### INTAKE SCREENING COMMENTS RESPONSE

Permit Number **2208-260**

Project Address 8455 SE 83<sup>RD</sup> ST.  
Mercer Island, WA 98040

Subject **Response to Building Permit Intake Screening Comments**

NOTE: REFER TO PLAN C10 FOR TREE PROTECTION FENCING INFORMATION, AND DIAGRAM 5/TS-4 FOR TREE PLANTING PLAN

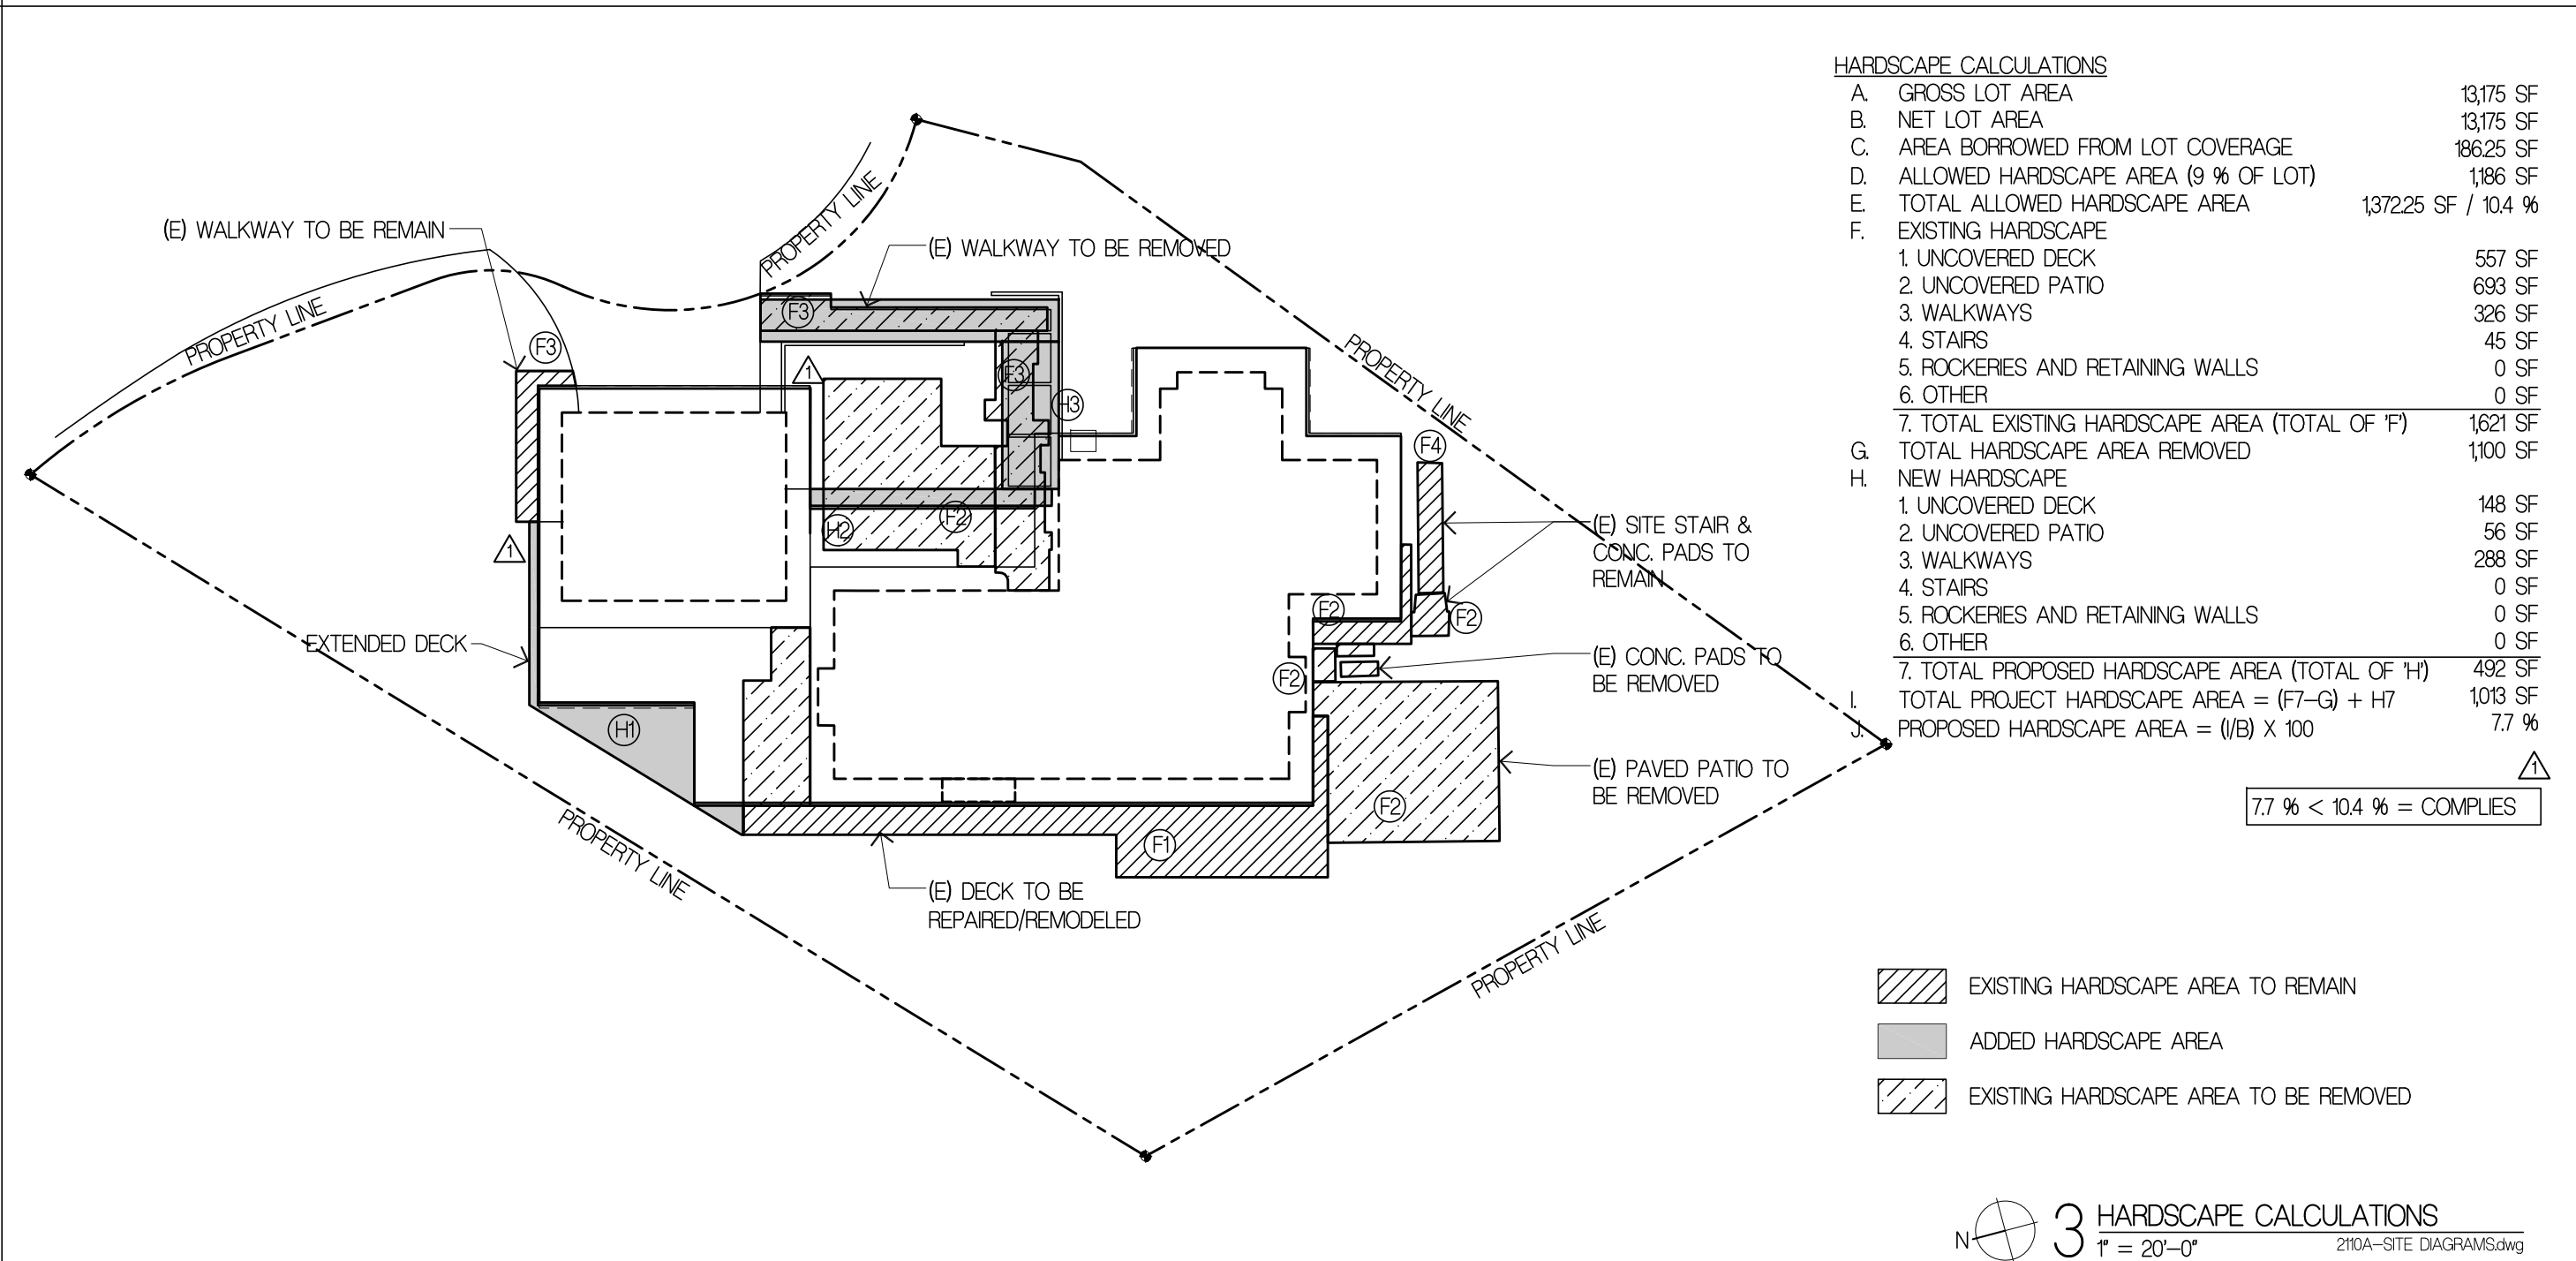
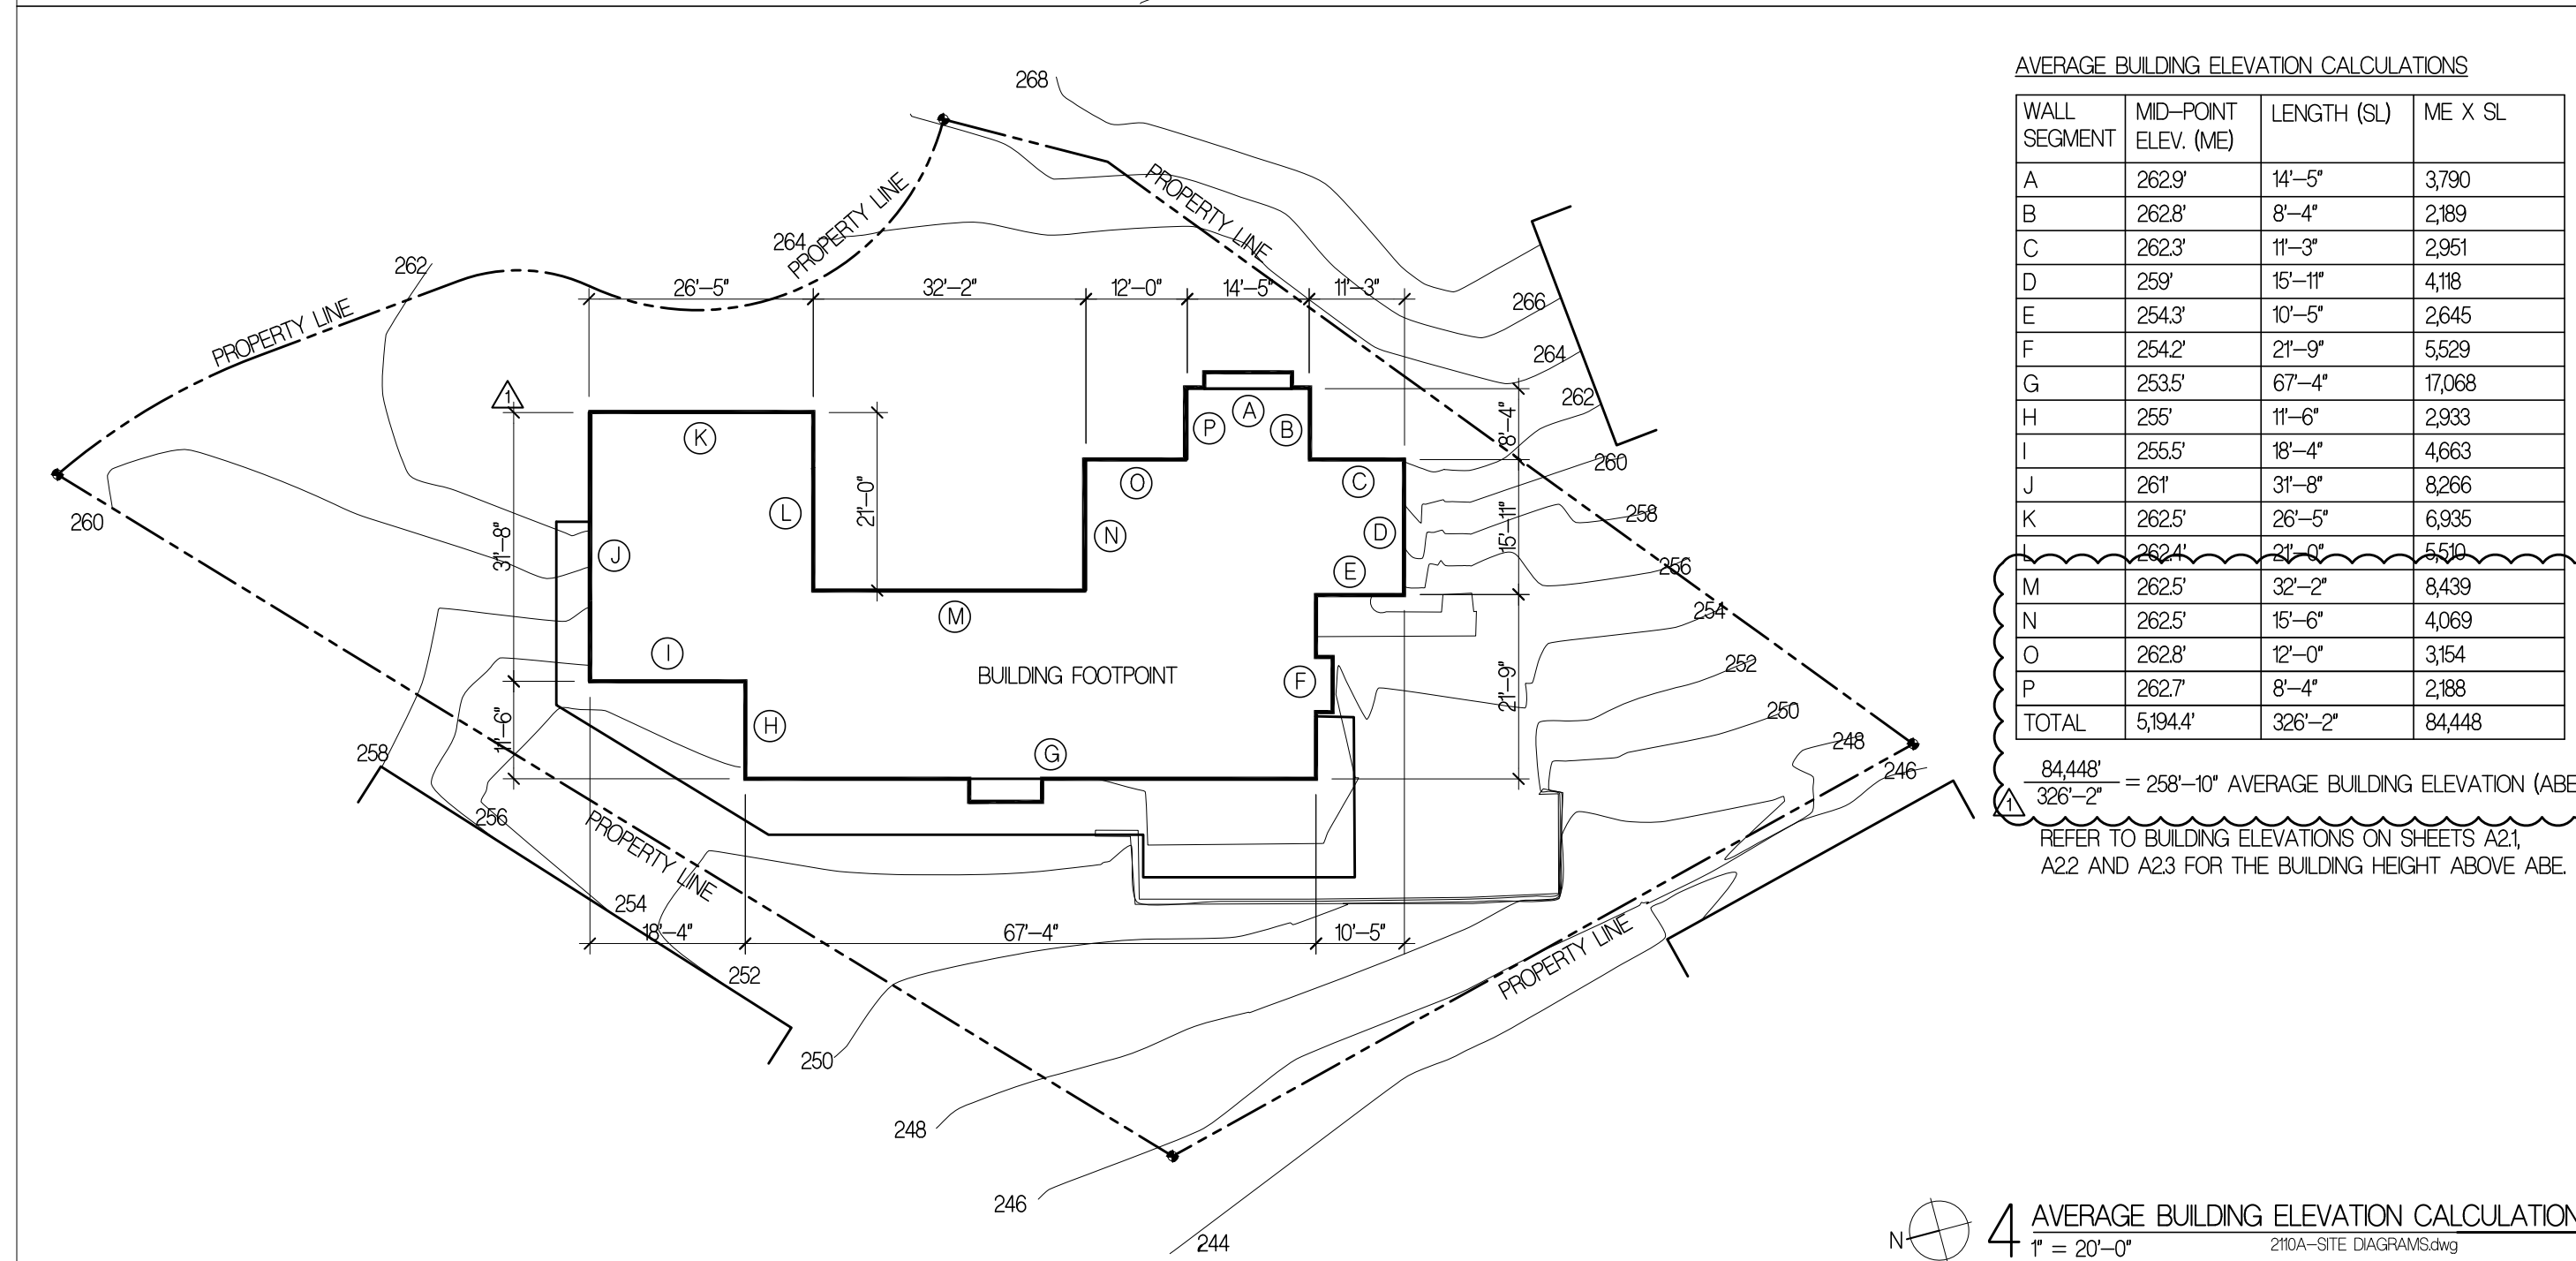
1. **Site Plan:**  
Response: As directed in the comment, Driveway length & widths have been noted on TS-2, Site Plan. The 2 minimum parking spaces required – this has been noted on TS-1 Project Information sheet under 'Zoning Information'.

4. **Critical Area on Plan:**  
Response: The dashed line showing the Critical Area shown on Site Plan sheet TS-2 has been made darker to enhance the visibility. The note is located near the bottom left of the drawing sheet.
